Roadway Plans_V1.pdf Markup Summary

CLEARWAY FILING NO. 2, LOT 5

CONSTRUCTION PLANS

**STORM 4 STA 1+00.00 TO STA 2+53.69**

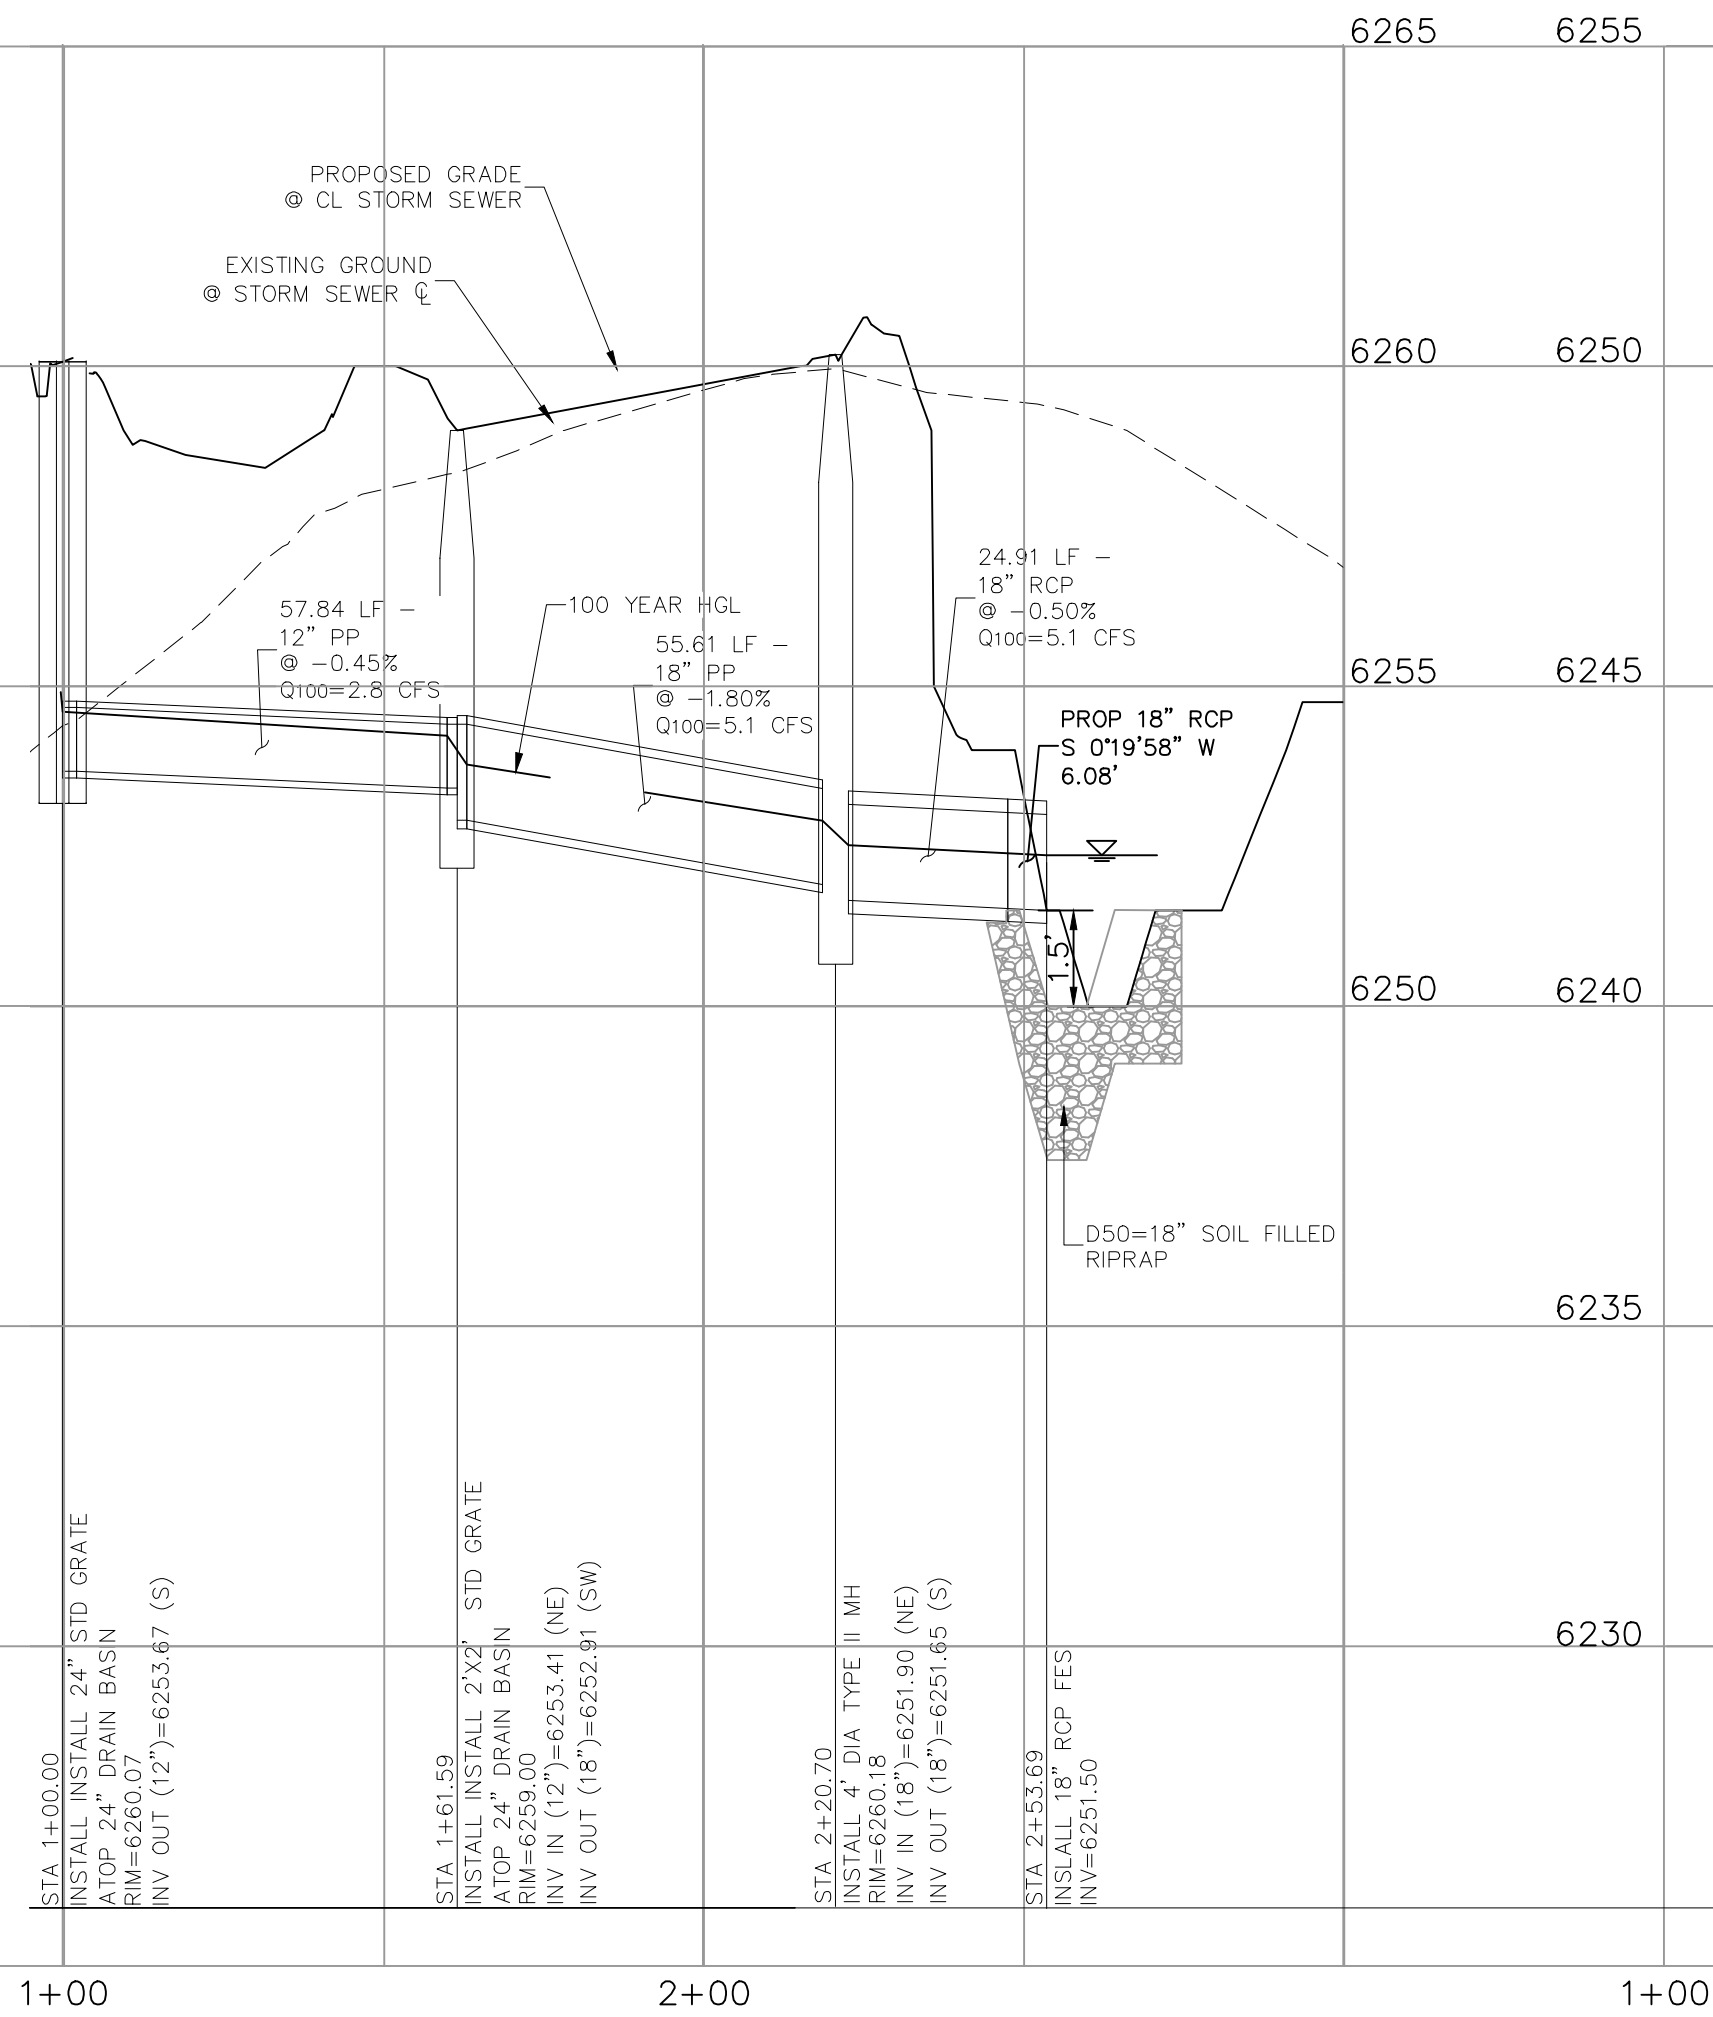
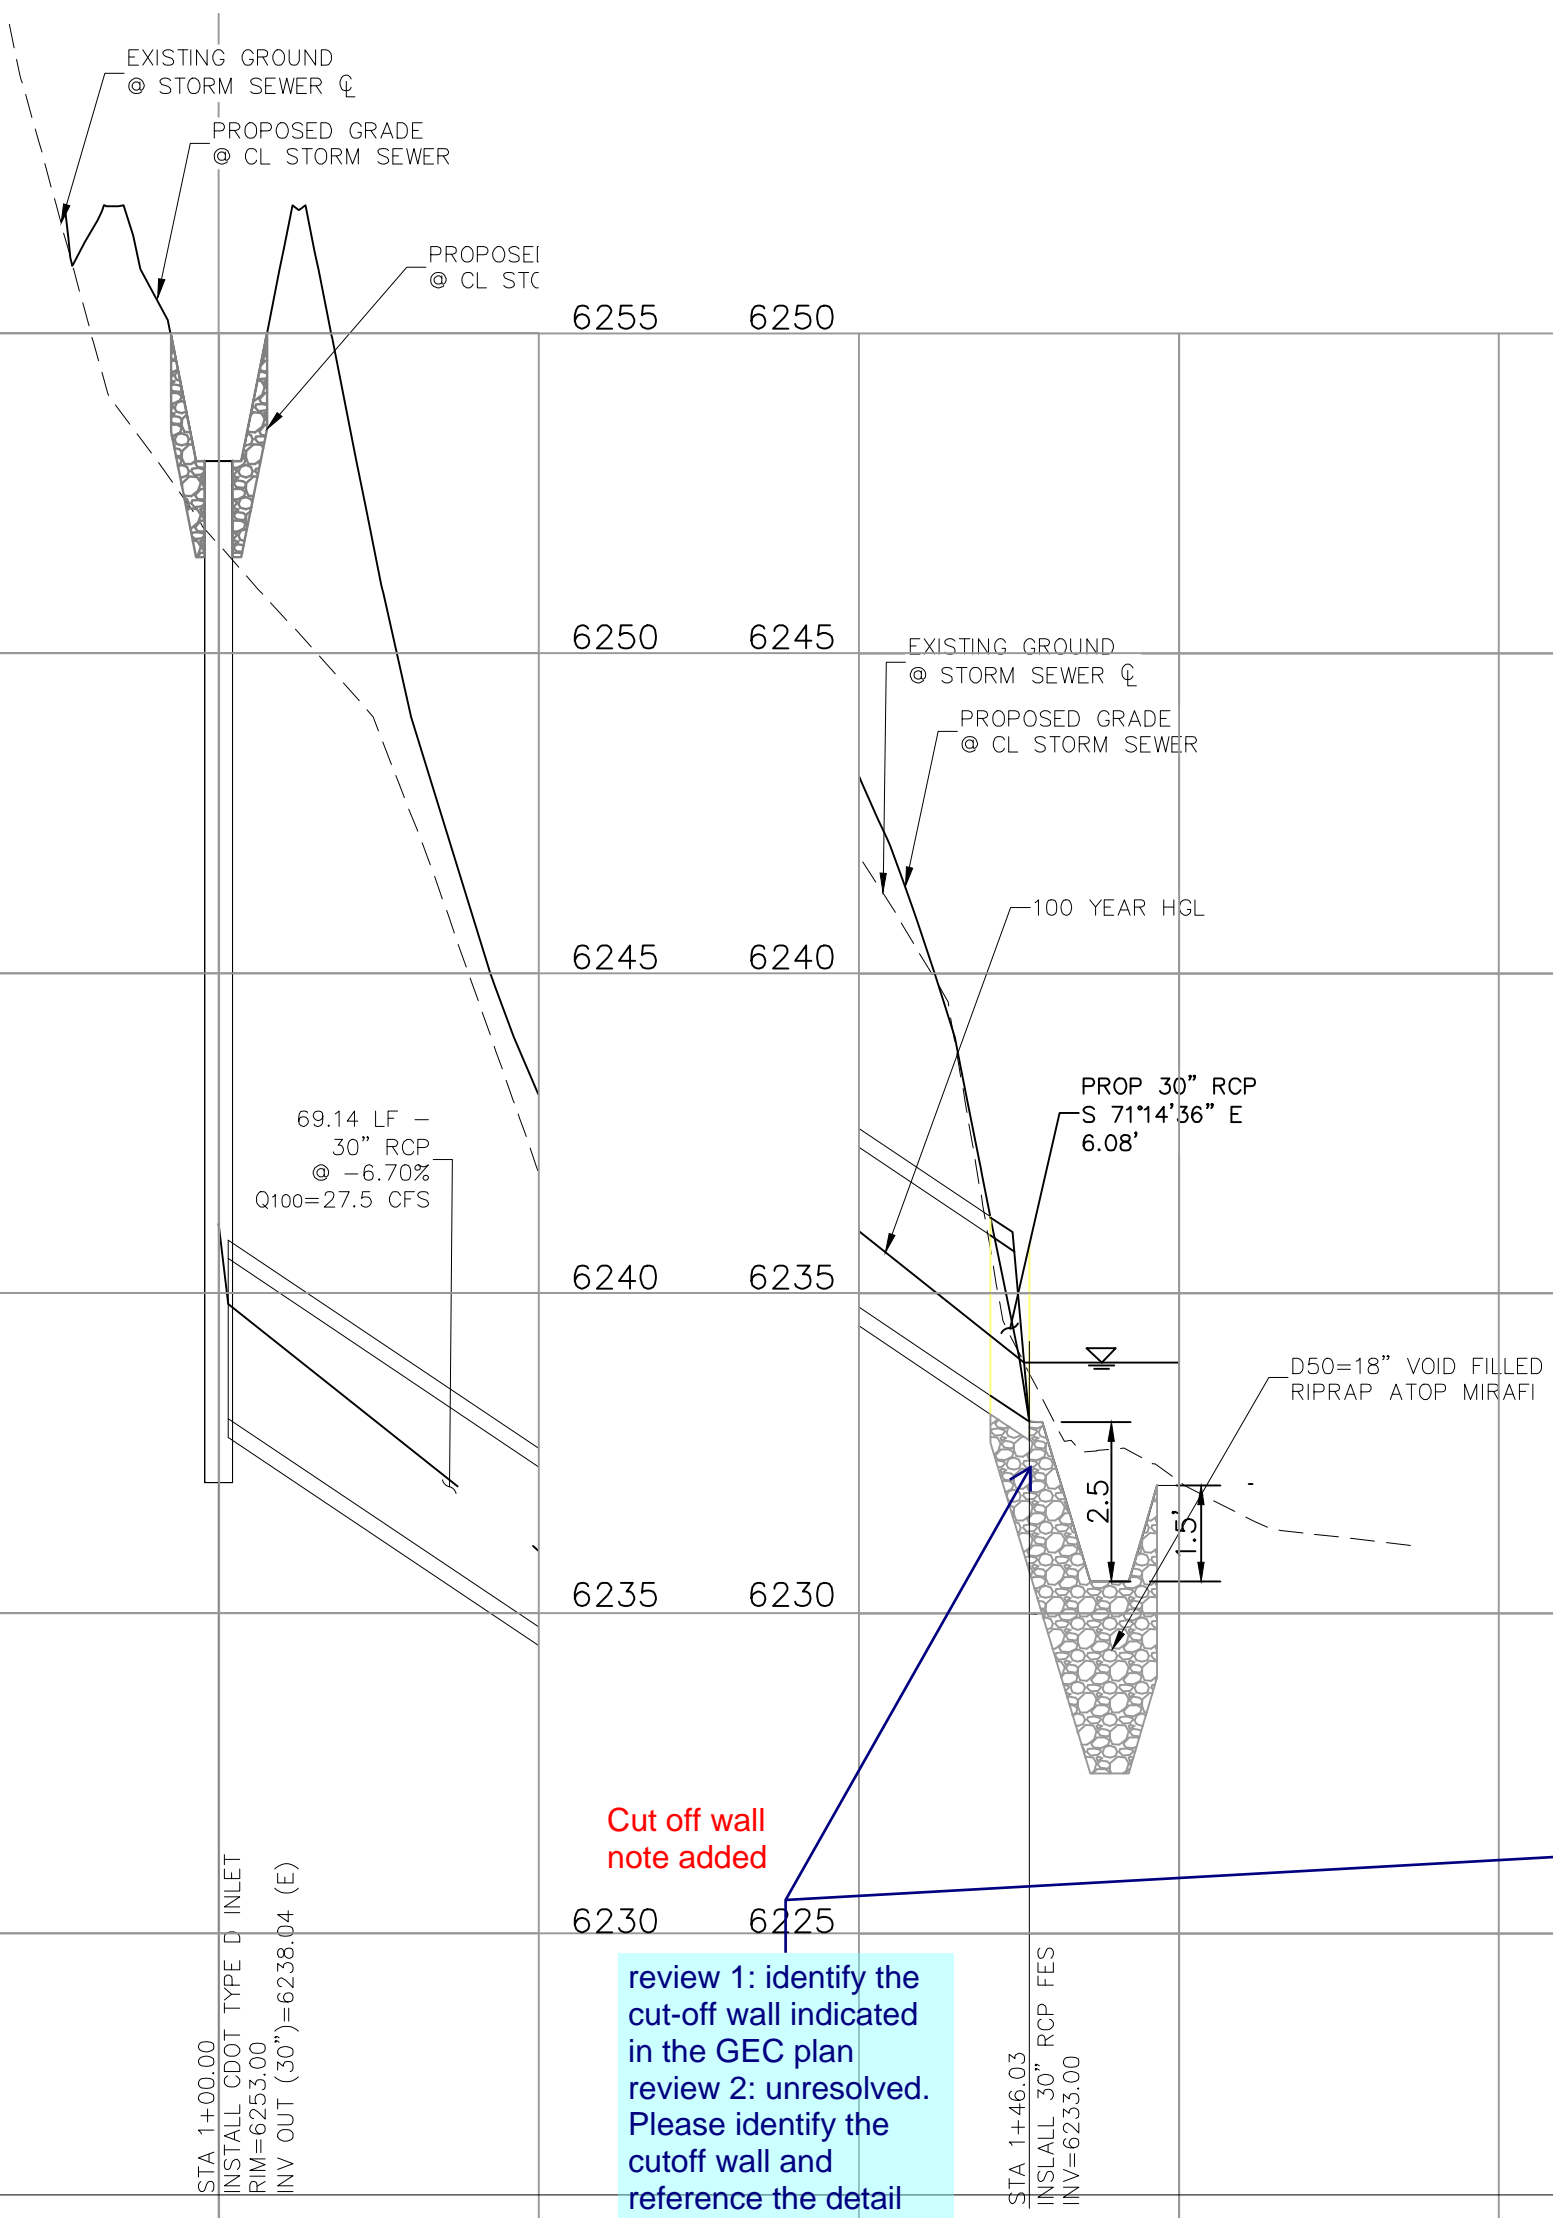
Show HGL lines on the profiles.

18" identified on the drainage plan. Revise accordingly.

identify the cut-off wall indicated in the GEC plan
